Objection to Indigo by Moran Seniors Living (SSD-76220734)

I am the owner of 6/150-152 Ocean Street, Narrabeen and have been for the past 4 years. As a 64 year old widower, this was a sea change for me downsizing from my large family home. The appeal for me to purchase this unit was the proximity to the beach and the lovely feel that Narrabeen offers. The other appeal was that the area does not allow high rise buildings.

Diagram 1 - East Elevation Ocean Street

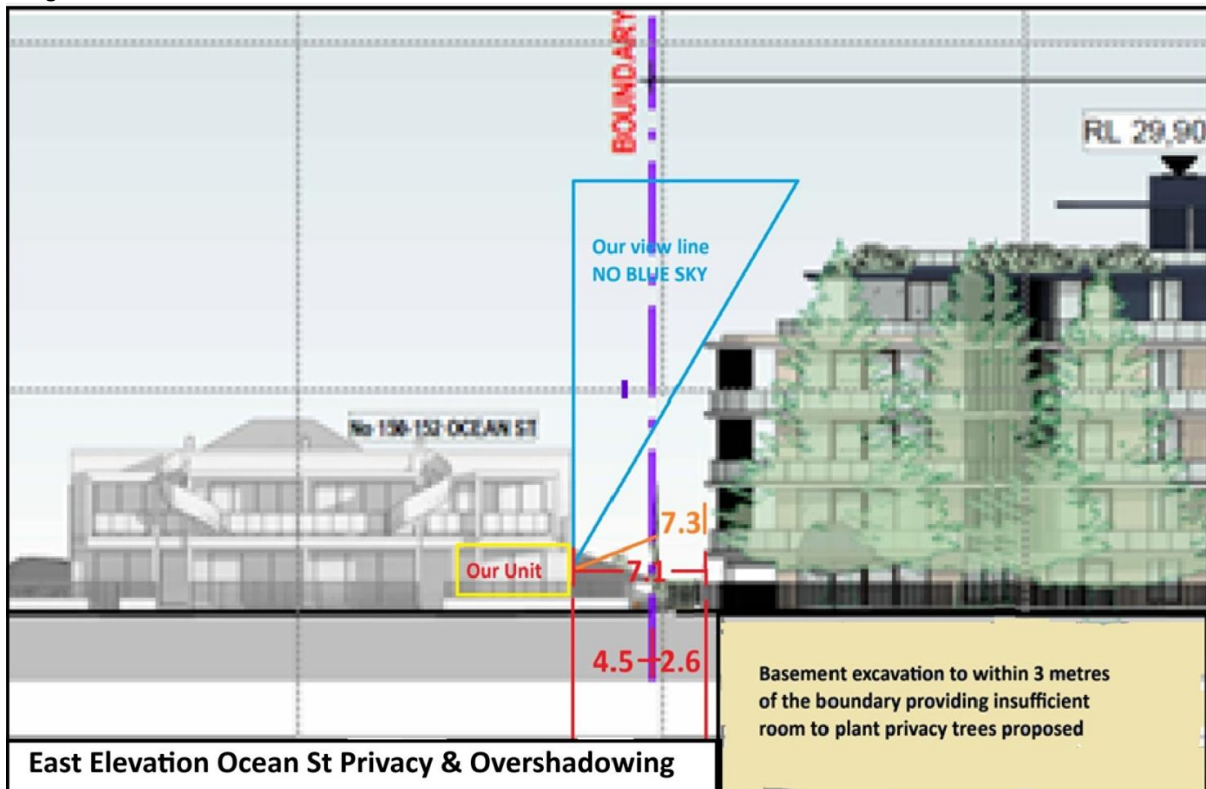
The height of the building is not in keeping with the neighbouring structures. The LEP permitted height is 8.5m. With the amended Clause 78 bonus height of 3.8m, this gives a combined height of 12.3m for the site. As shown in the below East Elevation diagram, the height measurement to the top of the roof is 28.700 which equates to 73% over the LEP permitted height.

The developer states that ***“At the street frontage, the building height is compatible with adjacent structures, maintaining a cohesive visual rhythm along the streetscape”***. The adjacent structure I believe is they refer to is 157 Ocean Street. They state that this building has a height of 21.946m to the top of the roof. I do not believe that to be the case and would ask that this be clarified.

How can there be “*a cohesive visual rhythm along the streetscape*” when the image below clearly shows that the proposed development overshadows all existing structures.

In light of the above, I request that the height be extensively scaled back to a level that is compatible with adjacent structures and in keeping with the neighbourhood.

Diagram 2 South Facing Balconies

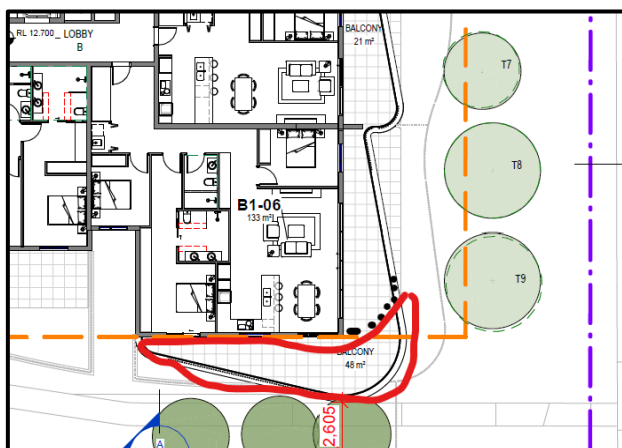
As shown below, the setback to 150 Ocean Street is 2.6m from the end of the balcony. How can this give our property any privacy, particularly to the owners of Units 4 and 8.

South Interface with 150 Ocean Street:– North facing windows are visible on the neighbouring facade, where a minimum of 2.6m setback is proposed for the south-eastern balconies from Ground Level to Level 3.

Propose that the balconies on the souther side be deleted so that the setback would be 9.3m.
